**WELWYN HATFIELD BOROUGH COUNCIL
EXECUTIVE DIRECTOR - PLANNING, PUBLIC PROTECTION AND GOVERNANCE**

DELEGATED APPLICATION

Application No: 6/2021/2513/HOUSE
Location: 8 Thistle Drive Hatfield AL10 9FQ
Proposal: Retention of conversion of garage into habitable space and proposed alterations to hardstanding to facilitate the creation of 1x car parking space.
Officer: Ms Kirsty Shirley

Recommendation: Refused

Drawing No: 5385-P01 Revision:

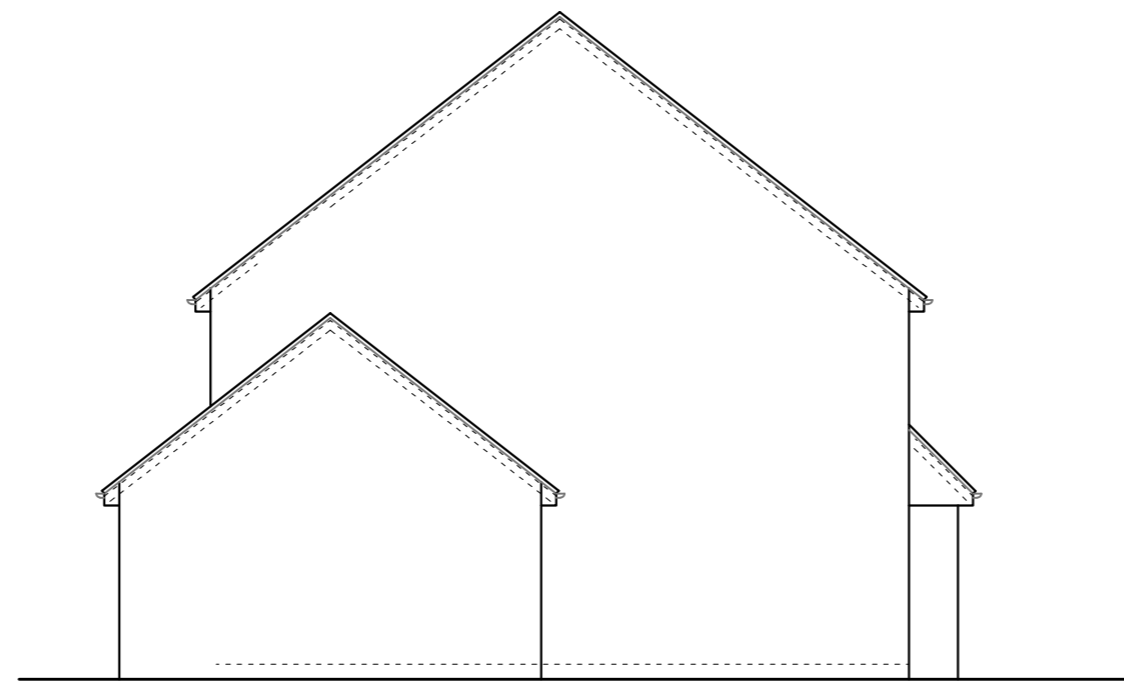
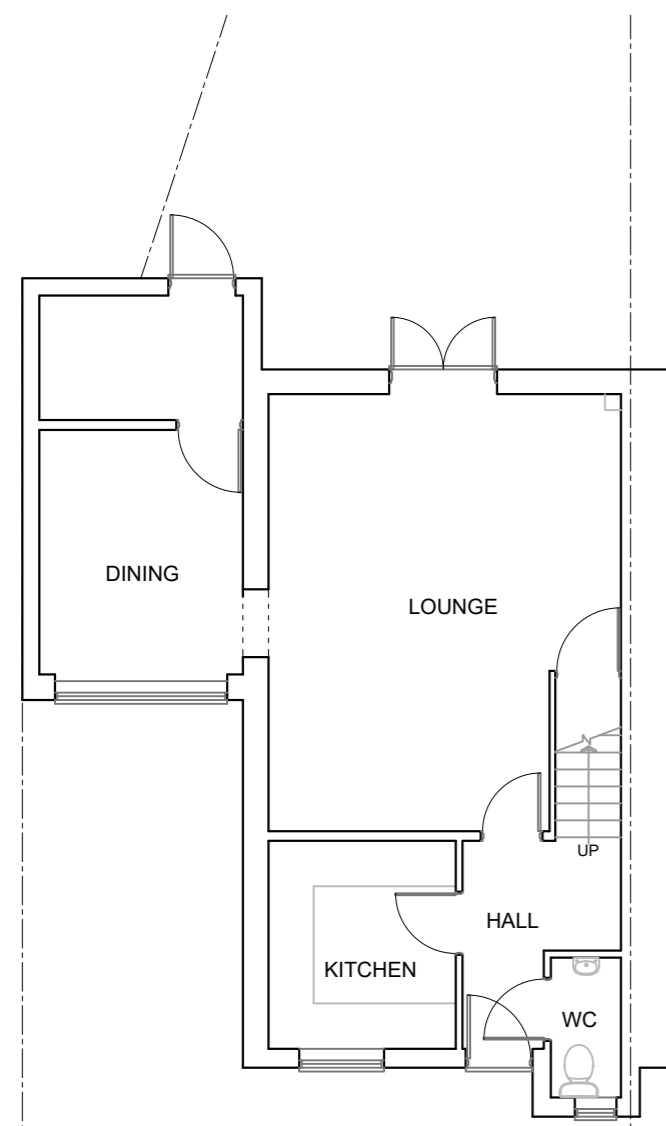
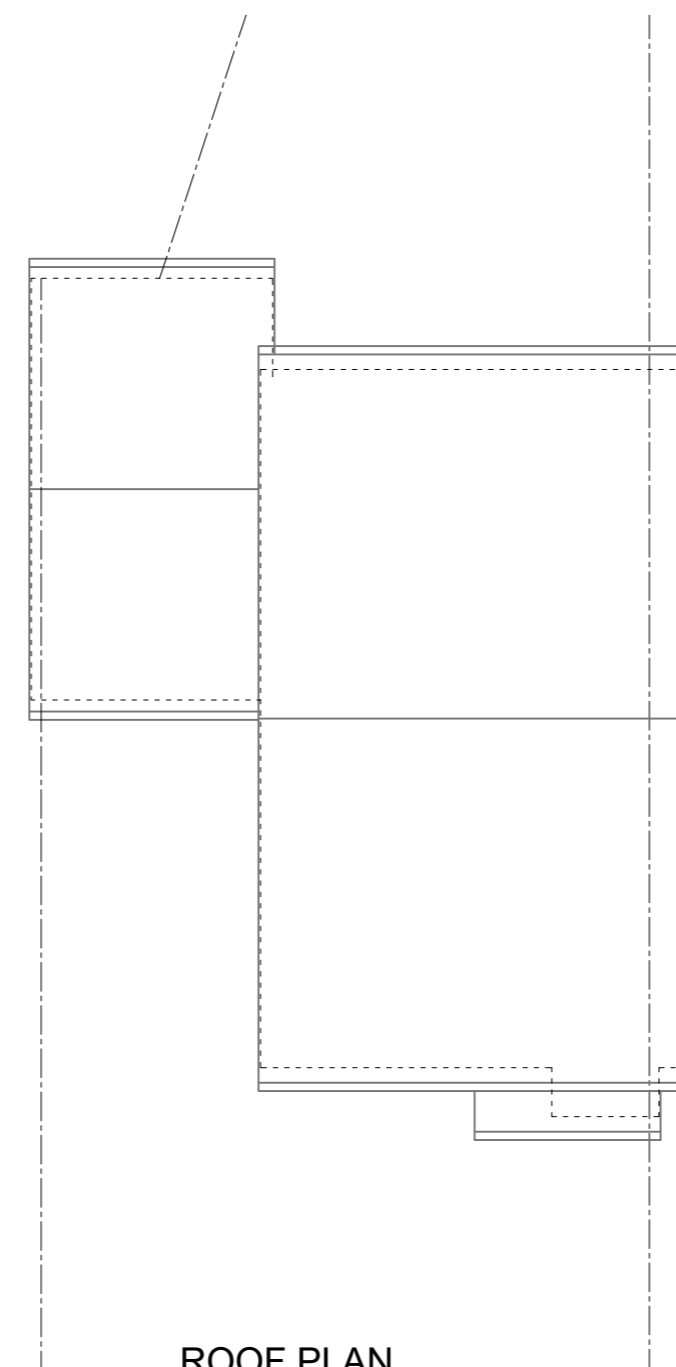
Consultations			
Neighbour representations	Support: 0	Object: 0	Other: 0
Publicity	Neighbour notification letter		
Summary of neighbour responses	None received		
Consultees and responses	Hatfield Town Council – no response		
Relevant Policies			
<input checked="" type="checkbox"/> NPPF <input type="checkbox"/> D1 <input checked="" type="checkbox"/> D2 <input type="checkbox"/> GBSP1 <input checked="" type="checkbox"/> GBSP2 <input checked="" type="checkbox"/> M14 <input checked="" type="checkbox"/> Supplementary Design Guidance <input checked="" type="checkbox"/> Supplementary Parking Guidance <input checked="" type="checkbox"/> Interim Policy for car parking and garage sizes Others: Hatfield Aerodrome Supplementary Planning Guidance			
Main Issues			
Design (form, size, scale, siting) and Character (appearance within the streetscene)	<p>The existing window within the previous front garage elevation is similar in design and style to the existing windows within the front elevation of the dwelling, and would respect and relate to the character of the existing dwelling and surrounding area.</p> <p>In regards to the creation of a driveway, the hardstanding would be located adjacent to a footpath and would be highly visible within the street scene.</p>

<p>However, it is commonplace within the street scene that driveways are not assuaged by any soft landscaping or boundary treatments, and in this case it is considered that the creation of a hardstanding in this location would not be detrimental to the character of the area.</p>
<p>Impact on neighbours</p>	<p>No neighbour representations have been received for this application.</p> <p>It is considered that the positioning and scale of the proposal would not result in adjoining neighbours to experience a detrimental loss of light or privacy, nor would the proposal appear unduly dominant towards adjoining neighbours.</p>
<p>Access, car parking and highway considerations</p>	<p>Paragraph 107 of the NPPF states that if setting local parking standards authorities should take into account the accessibility of the development; the type, mix and use of the development; the availability of and opportunities for public transport; local car ownership levels; and the need to ensure an adequate provision of spaces for charging plug-in and other ultra-low emission vehicles.</p> <p>The Council's Interim Car Parking and Garage Policy confirms that planning applications will be determined on a case-by-case basis to achieve a sensible level of parking provision taking account of existing SPG standards, NPPF guidance, the relevant circumstances of the proposal, its site context and its wider surroundings.</p> <p>The applicant has described the resultant habitable room following the garage conversion is to be used a dining room and utility room. The Council's Hatfield Aerodrome SPG 1999 applies to this dwelling and requires two car parking spaces for a 2-3 bedroom dwelling. The application site has three bedrooms as advised by the applicant.</p> <p>The Interim Policy for Car Parking Standards and Garage Sizes outlines that many existing domestic garages are too small for their intended purpose for parking/storing vehicles. The Council will seek to ensure that new garages have a genuine ability to be used for their intended purpose and will require them to be at least 6 metres long by 3 metres wide and sufficiently tall to accommodate modern cars. Whilst dimensions of the previous garage fall below the identified size requirements, at approximately 5.3m in length and approximately 2.6m in width, these measurements could reasonably park a vehicle and it is therefore considered that the loss of the garage has resulted in the loss of a car parking space.</p> <p>The application site benefits from a front driveway suitable for parking one vehicle. The proposal also includes the creation of an additional car parking space within the existing front garden. The existing driveway space is approximately 4.5m in length and 2.2m in width. The proposed driveway would be an unusual shape due to the curved frontage of the application site. The length of the proposed driveway would measure approximately 3.9m in length, but due to the curved shape of the driveway, only 2.5m of the driveway length would be suitable to park on without risk of a vehicle parking on and subsequently blocking the adjoining footpath. There are few, if any, car models that are 2.5m in length, and it is therefore considered that the proposed driveway would not be suitable to park a vehicle. Additionally, the applicant does not intend to make amendments to the highway, i.e. a dropped kerb, and it is unclear how the proposed driveway space would be accessed should a vehicle be parked in the existing driveway, without utilising the footpath and</p>

<p>subsequently endangering pedestrians.</p> <p>It is acknowledged that there are garage conversions within the vicinity of the application site, notably 1 Thistle Drive and 3 Daisy Drive. These addresses sought planning permission in 2014 and 2015 respectively, and it was considered in these cases the conversion of the garage would not result in a net loss of car parking spaces.</p>
Conclusion	
<p>The permitted development rights were removed from this property in the interest of visual amenity and highway safety. From a recent site visit at public vantage points, there were a considerable number of vehicles parking on the street, and to avoid blocking the road, vehicles were parked across the footpath, severely reducing the width of the footpath. Parking in this manner endangers pedestrians and causes accessibility issues for those with pushchairs, wheelchairs etc. who may be forced to travel in the road, further endangering themselves. Paragraph 111 of the National Planning Policy Framework states development should be refused on highway grounds if there would be an unacceptable impact on highway safety.</p> <p>Furthermore, the garage conversion has resulted in the loss of one parking space and the proposed driveway space is not conducive to useable car parking space, resulting in a net loss of one car parking space, an unacceptable loss in this location.</p> <p>The proposal would therefore have significant impact on the safety and operation of the adjoining highway network contrary with Policies D1 and M14 of the Welwyn Hatfield District Plan; the Interim Policy for Car Parking Standards and Garage Sizes; and the National Planning Policy Framework.</p>

1. The proposal would have significant impact on the safety and operation of the adjoining highway network, and would result in an unacceptable loss of a car parking space, contrary with Policies D1 and M14 of the Welwyn Hatfield District Plan; the Interim Policy for Car Parking Standards and Garage Sizes; and the National Planning Policy Framework.
